Our ref: NO/2012/104434/01-L01
Your ref: 3/2012/0669

Date: 02 November 2012

ERECTION OF INDUSTRIAL UNIT AND ALTERATIONS TO PARKING PROVISIONS LINCOLN WAY, CLITHEROE

Notes:

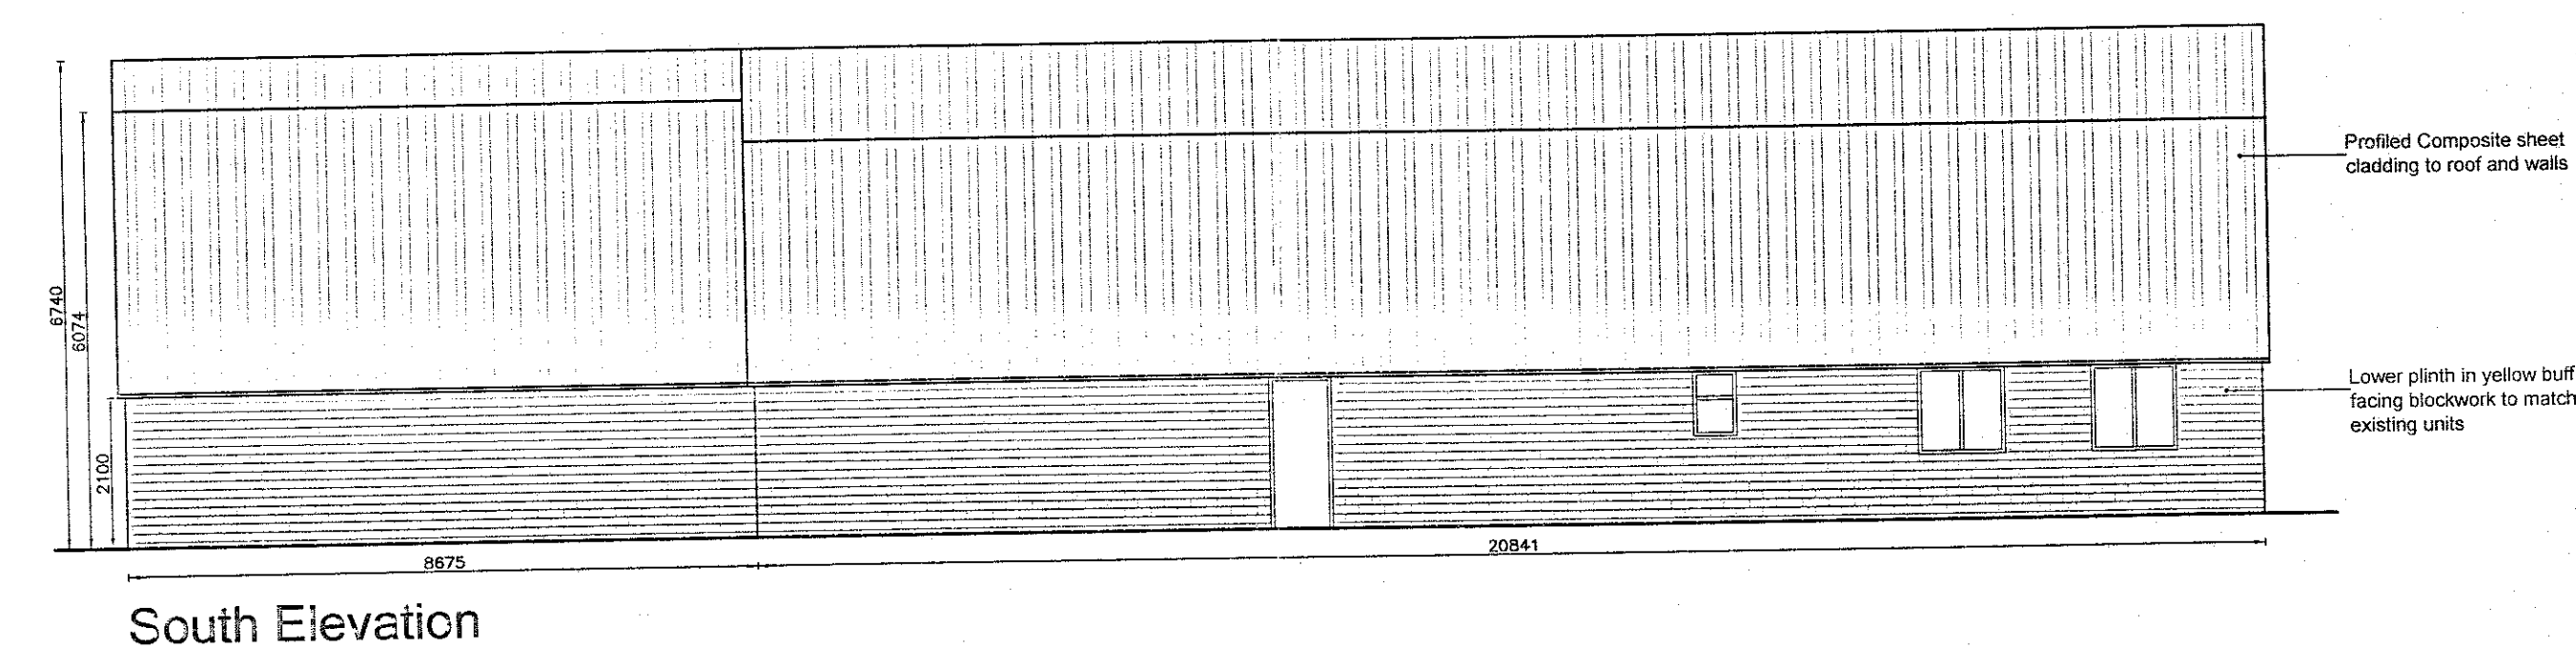
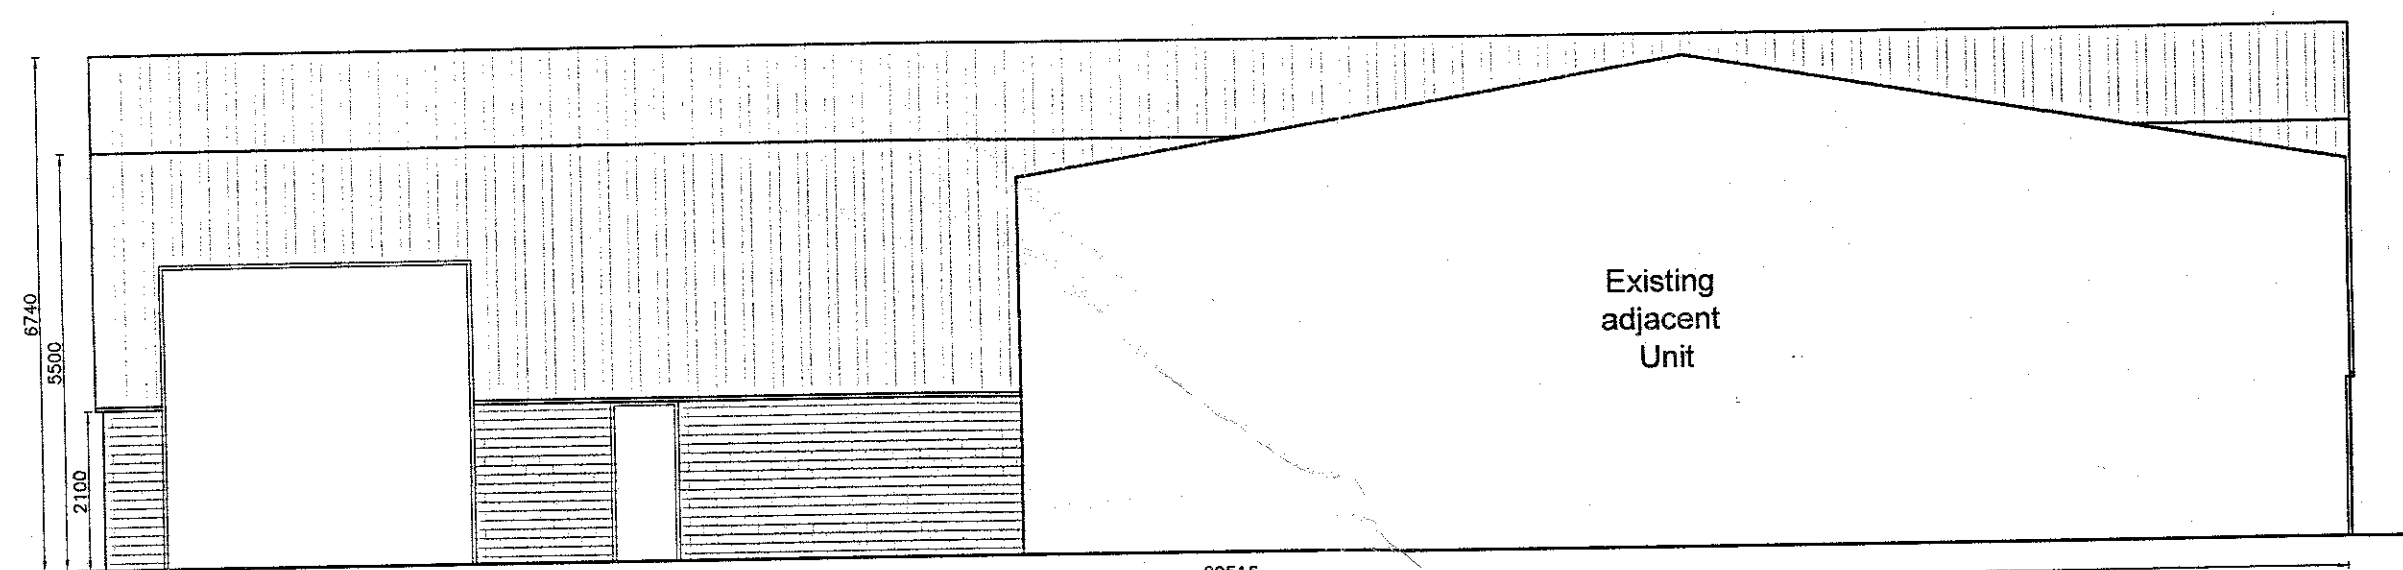
Mearley Brook is a designated Main River, Land Drainage Byelaws No.7 imposes restrictions to the effect that no trees or shrubs may be planted, fences, buildings, pipelines or any other structure erected within 8 metres of the top of the bank of the watercourse without the prior written Consent from the Environment Agency.

The Agency would be unlikely to give consent for the developments because it would unduly restrict essential maintenance and emergency access to the Main River watercourse. The permanent retention of a continuous unobstructed area is an essential requirement for future maintenance and improvement works to this river.

Additionally, our Biodiversity and Fisheries team have advised that building this close to the watercourse has the potential to negatively impact on the wildlife using the watercourse and embankments. A sufficient buffer zone must be maintained to ensure that wildlife habitats and water quality are not negatively impacted.

The scheme should be revised in order to maintain appropriate access arrangements and a suitable wildlife corridor next to the watercourse. The revised scheme should not significantly encroach within 8 meters of the top of the river bank.

We recommend that the applicant contact us to discuss our access requirements and provide revised cross-sectional plans and drawings showing the top of the riverbank and detail how the revised scheme will incorporate these requirements.
